# Comments for Planning Application 21/0048/FUL

Application Number: 21/0048/FUL

Address: 1 Parson Street London NW4 1QD

Proposal: Demolition of existing building and construction of part three/part four storey mixed use building comprising 9 residential units and office floorspace at ground floor level. Associated amenity space, refuse storage, cycle parking and off-street parking

5-7 Florence Street – Rear

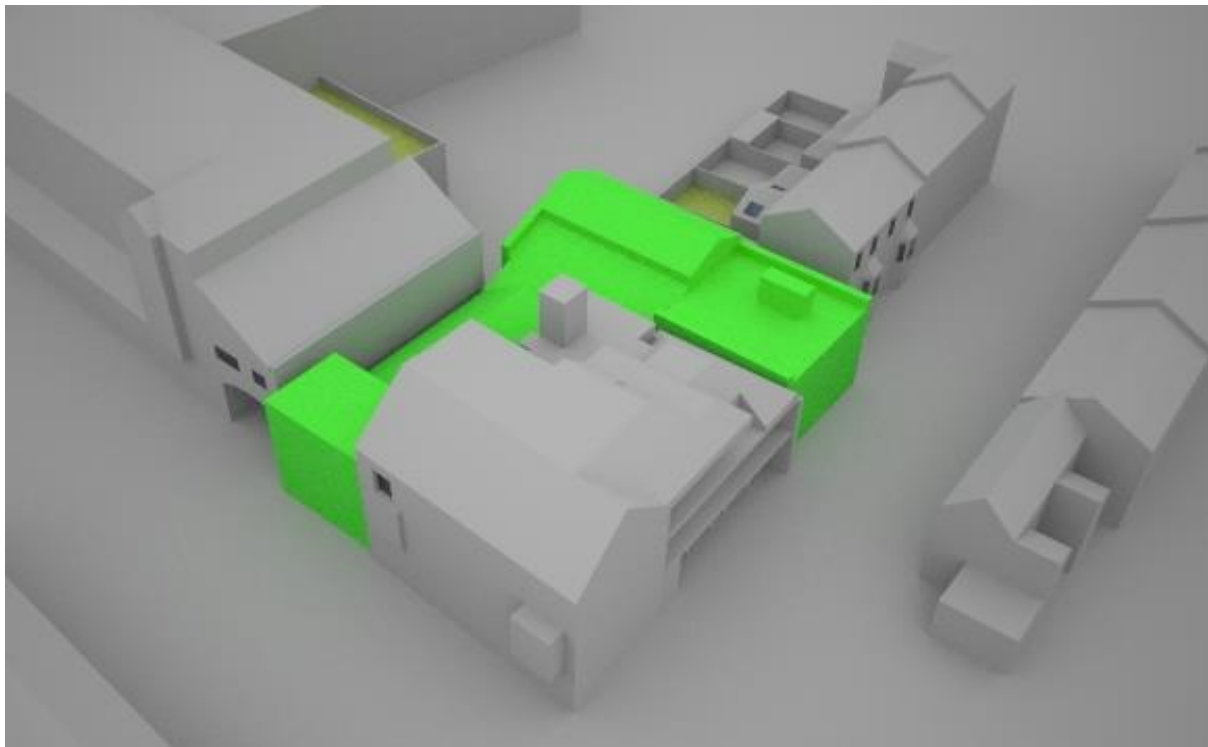
- The current plans do not fully take into consideration the most recent layout of our house. We have recently completed a house extension, permission for which was granted in December 2019 by Barnet Council. Therefore, all plans and assessments would need to be amended throughout to take into account the new details of our house. Significantly, whilst some of the documents mention our development, the sunlight/daylight report (see p27) does not assess the impact on the building as extended.

- The proposed building will affect the daylight into our house. There are two new windows on the side of our house, one whose very purpose is to allow for daylight into the above hallway which otherwise would have no direct natural light and one into the upstairs bathroom. The downstairs rear of our house has large glass doors/windows. The planned size of the building will affect the amount of daylight into both the windows and the rear of the building, and the impact on VSC has not been assessed.

Proposed Rear Elevation

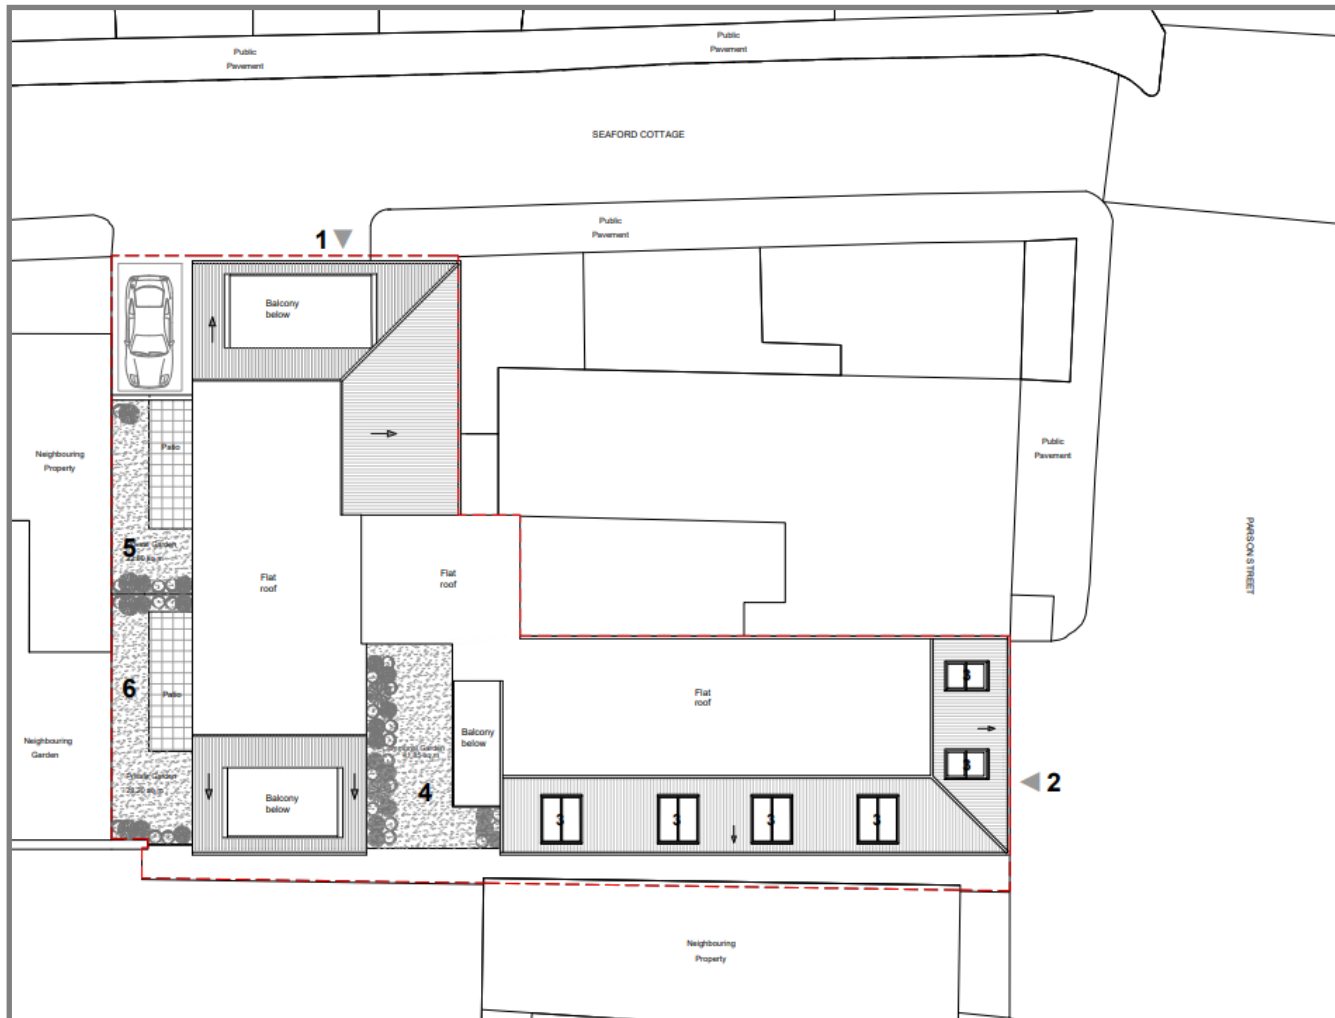
- We are concerned that the windows and doors on the proposed rear elevation will allow its residents to view into our garden and our rear garden doors/windows. We would like them to be removed. The Council's Residential Design Guidance and Sustainable Design and Construction SPDs are both very clear on this point stating respectively that "habitable rooms and areas of

private gardens close to dwellings should not be excessively overlooked by windows or elevated amenity areas such as balconies/terraces [CONTINUED IN NEW COMMENT SUBMITTED]
